WEST SUSSEX COUNTY COUNCIL CONSULTATION

TO:	Arun District Council FAO: Mrs A Gardner
FROM:	Highways, WSCC
DATE:	25/05/2018
LOCATION:	Directors Cottage, Toddington Lane, Littlehampton, BN17 7PP
SUBJECT:	LU/120/18/DOC Approval of details reserved by condition imposed under LU/249/17/PL relating to conditions 3- Construction Management Plan, 5-visibility splays, 15- landscape scheme & 16-schedule of materials & finishes.
DATE OF SITE VISIT:	
RECOMMENDATION:	☐ Advice ☐ Objection ☐ Modification ☐ No Objection ☒ More Information ☐ Refusal
S106 CONTRIBUTION TOTAL:	£N/A

Drawing: DETAILS [re:conditions 5&16]

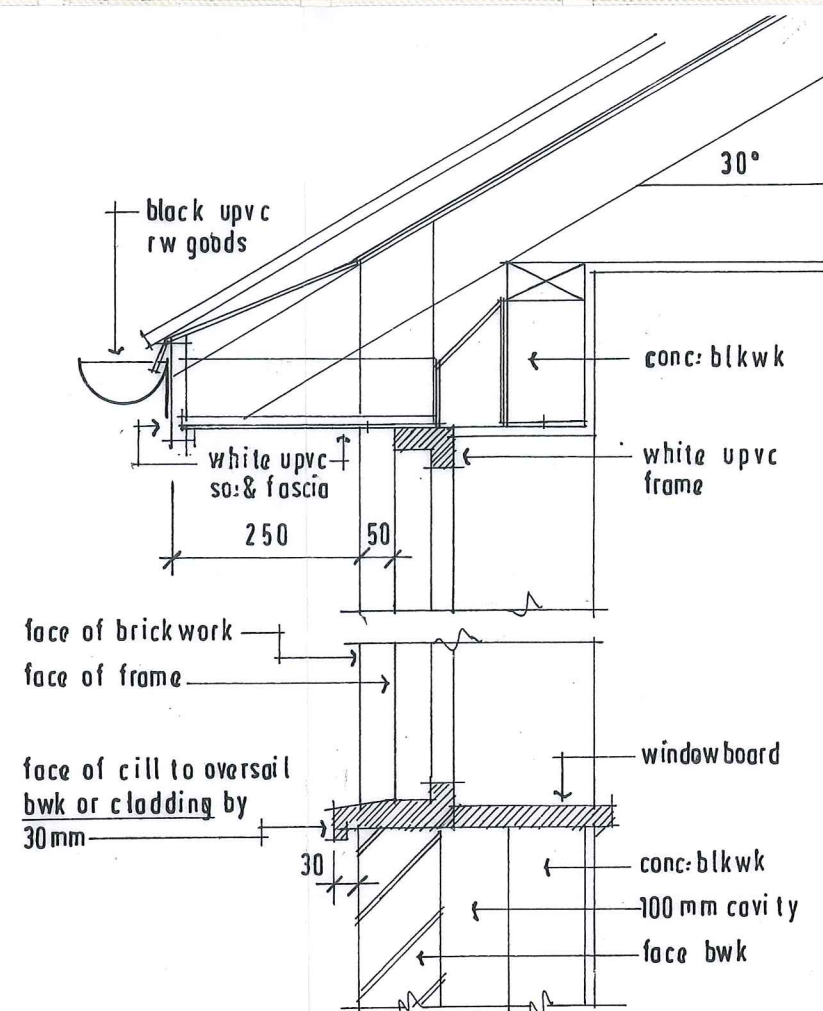
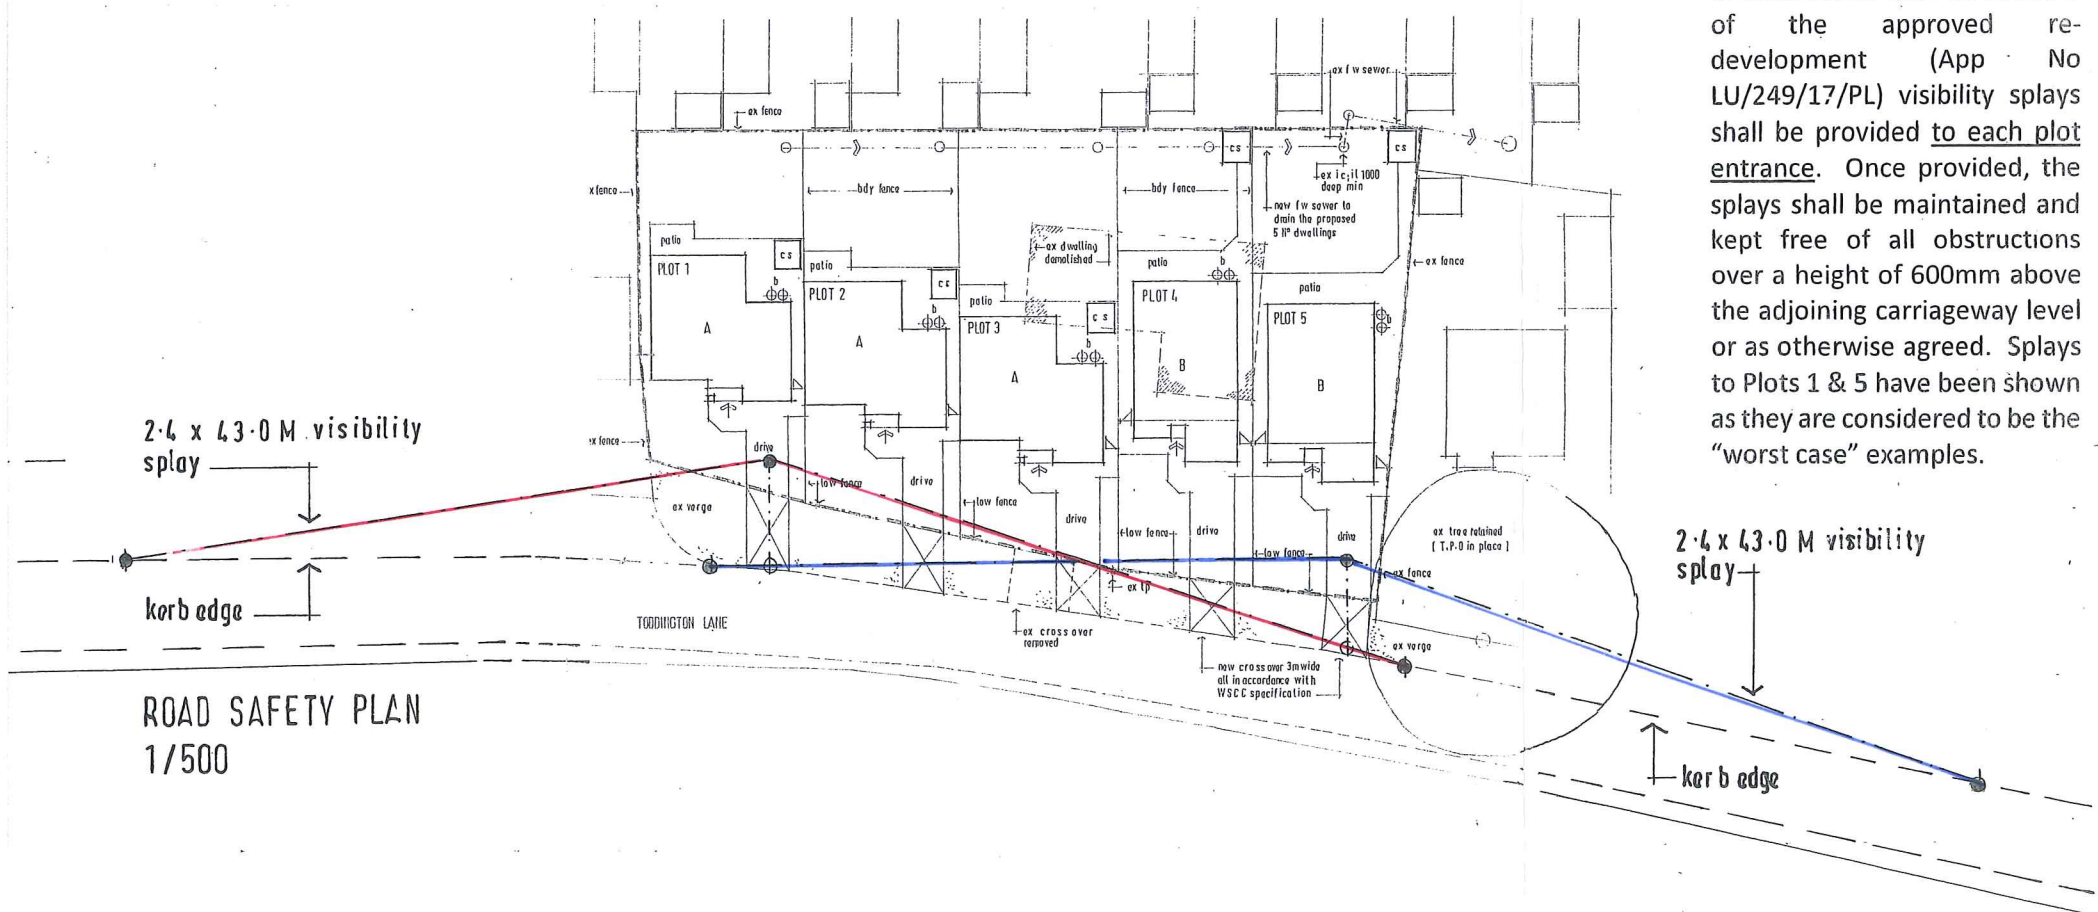
Visibility splays are to be drawn from 2.4m set back distance from the edge of the highway, at a point where a driver's eye line would be whilst waiting to emerge onto the highway. The plans as demonstrated show the visibility splays taken from 2.4m into the site.

The splays must span to the nearside edge of the highway as has been demonstrated within Manual for Streets guidance below and must not intersect third party land.

Once this amended plan has been provided, please re-consult.
